CITY OF ALBUQUERQUE

**Planning Department
Transportation Development Services Section**

Re: Certification Submittal for Final Building Certificate of Occupancy for
Used Auto-Dealership, [C-18 / D35A]
5301 Alameda Blvd NE
Architect's Stamp Dated 07/11/05

Re: Traffic Certification for
Permanent Certification of Occupancy

**SITE PLAN-TCL**

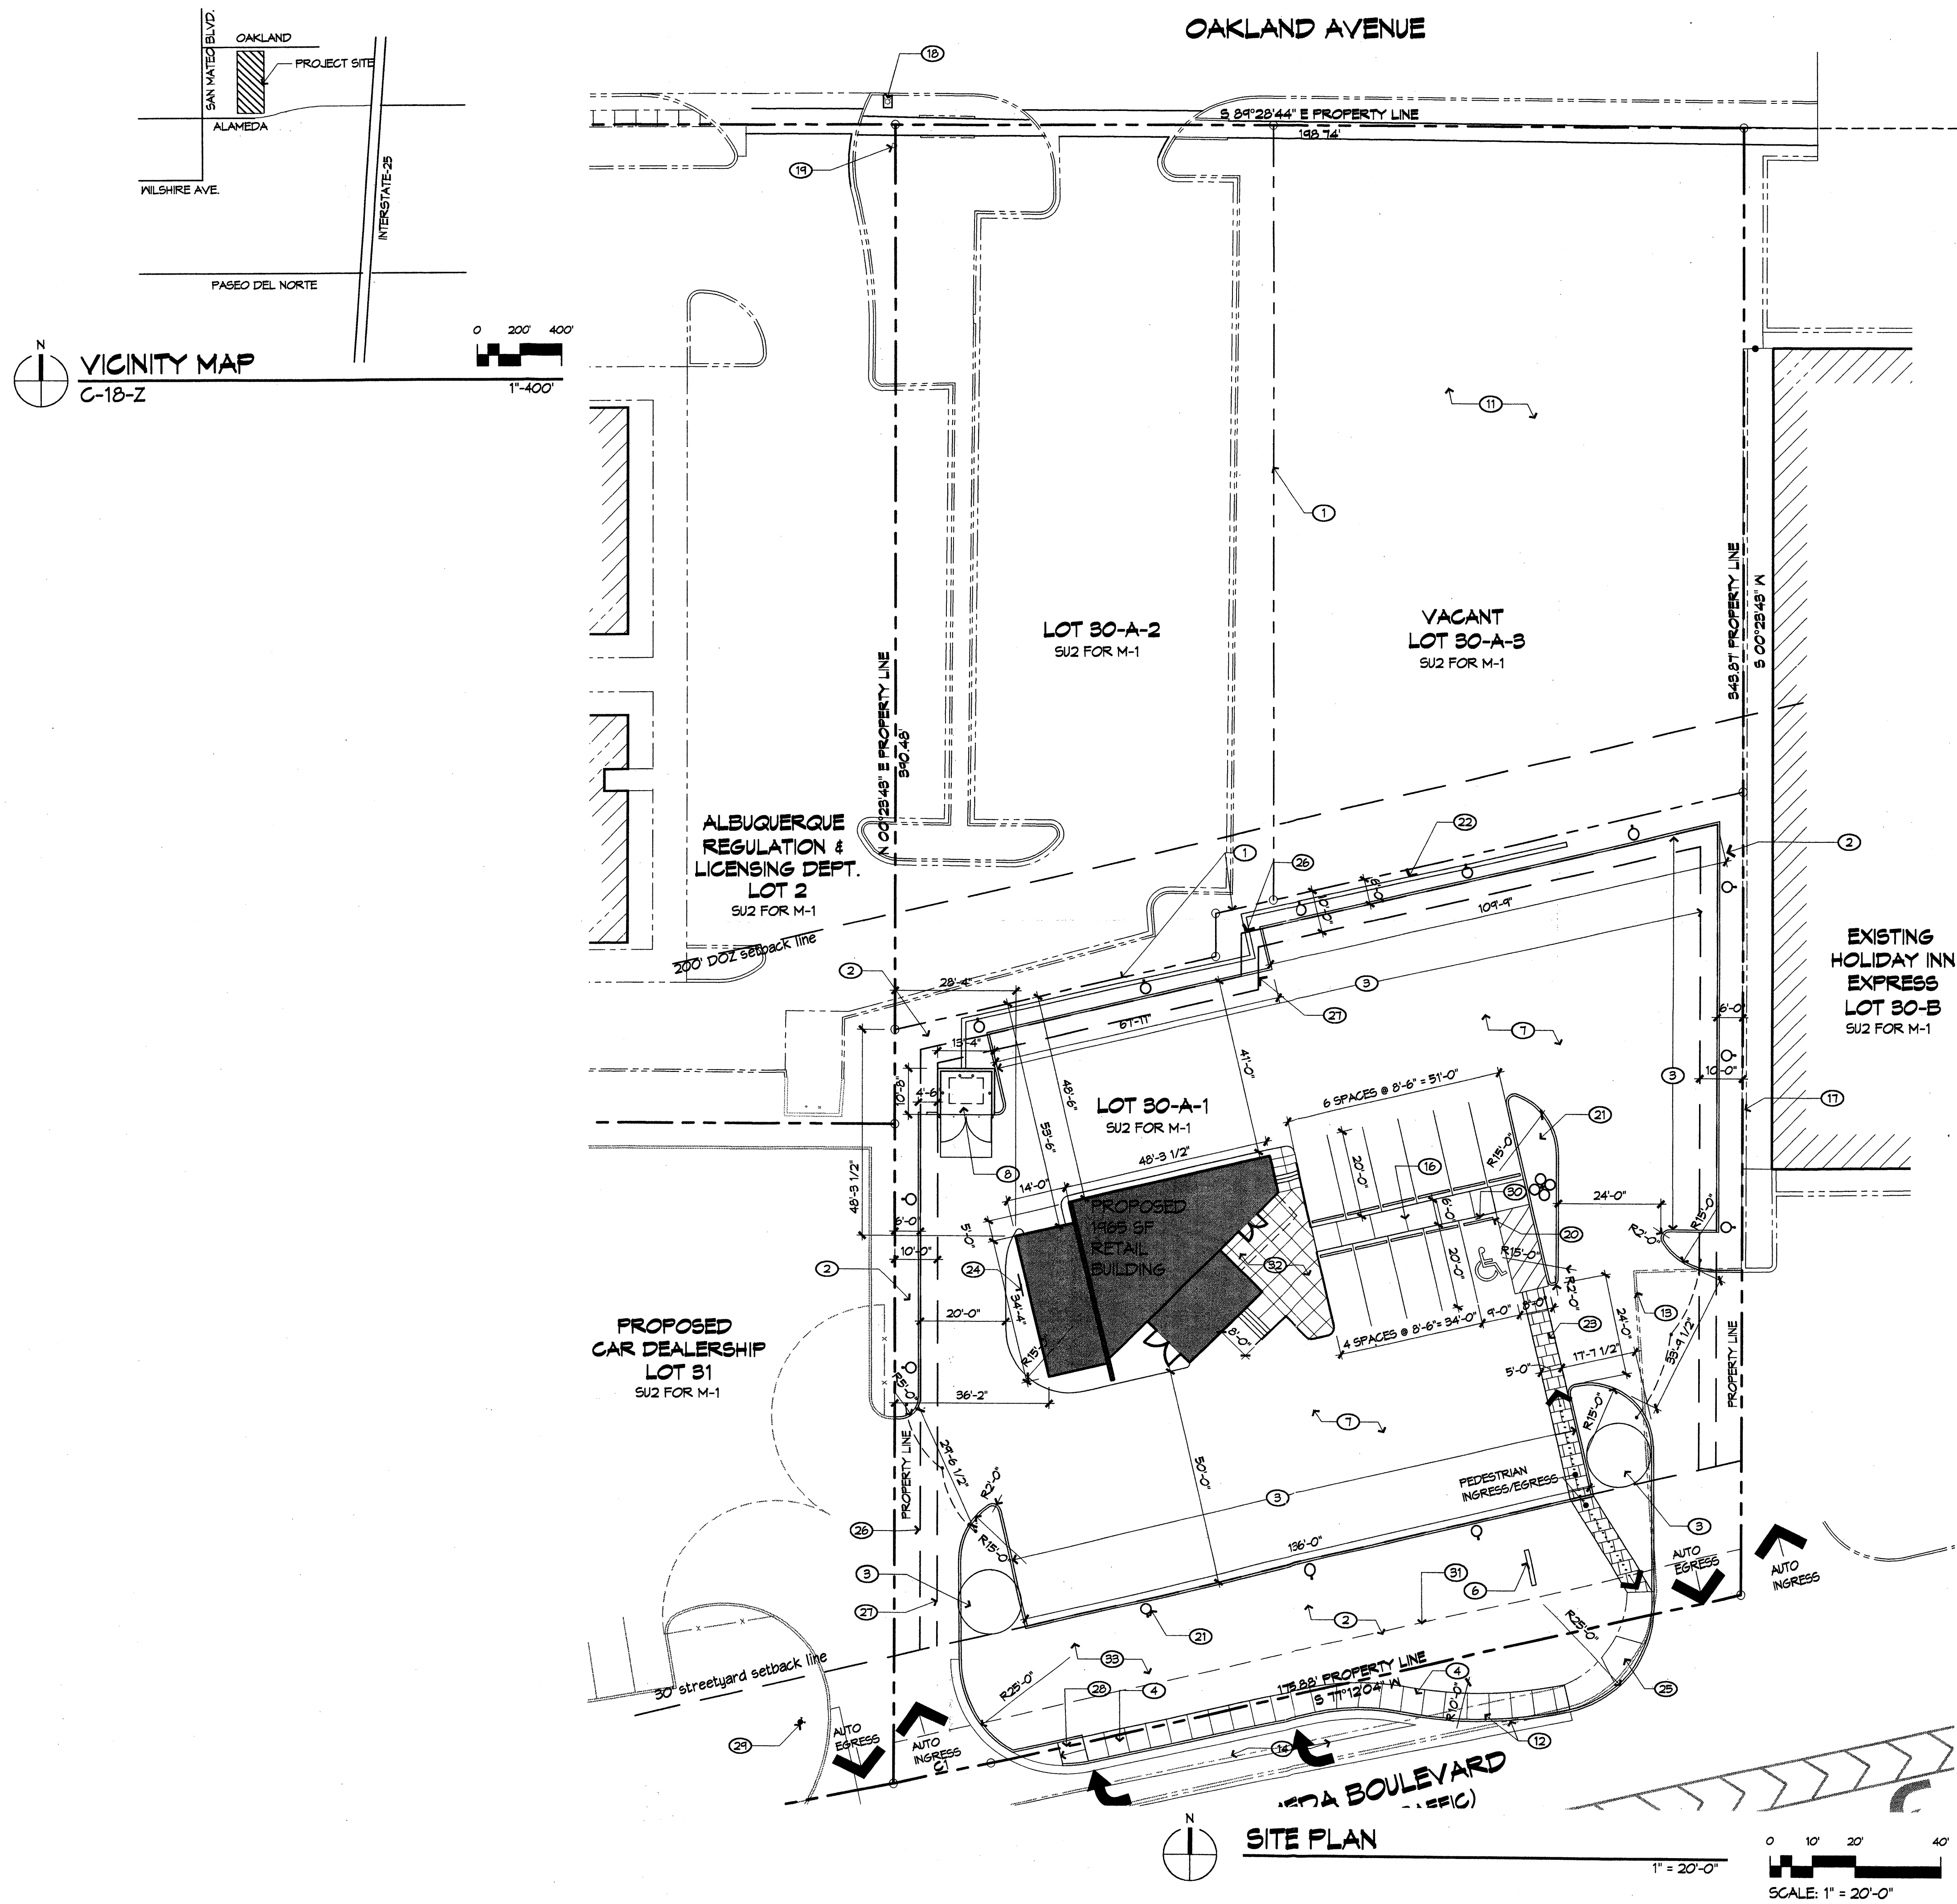
1. Increase the sidewalk width to 10 feet, or add bumpers to the parking
spaces.

→ Put bumpers in or increase
the sidewalk width to 10'
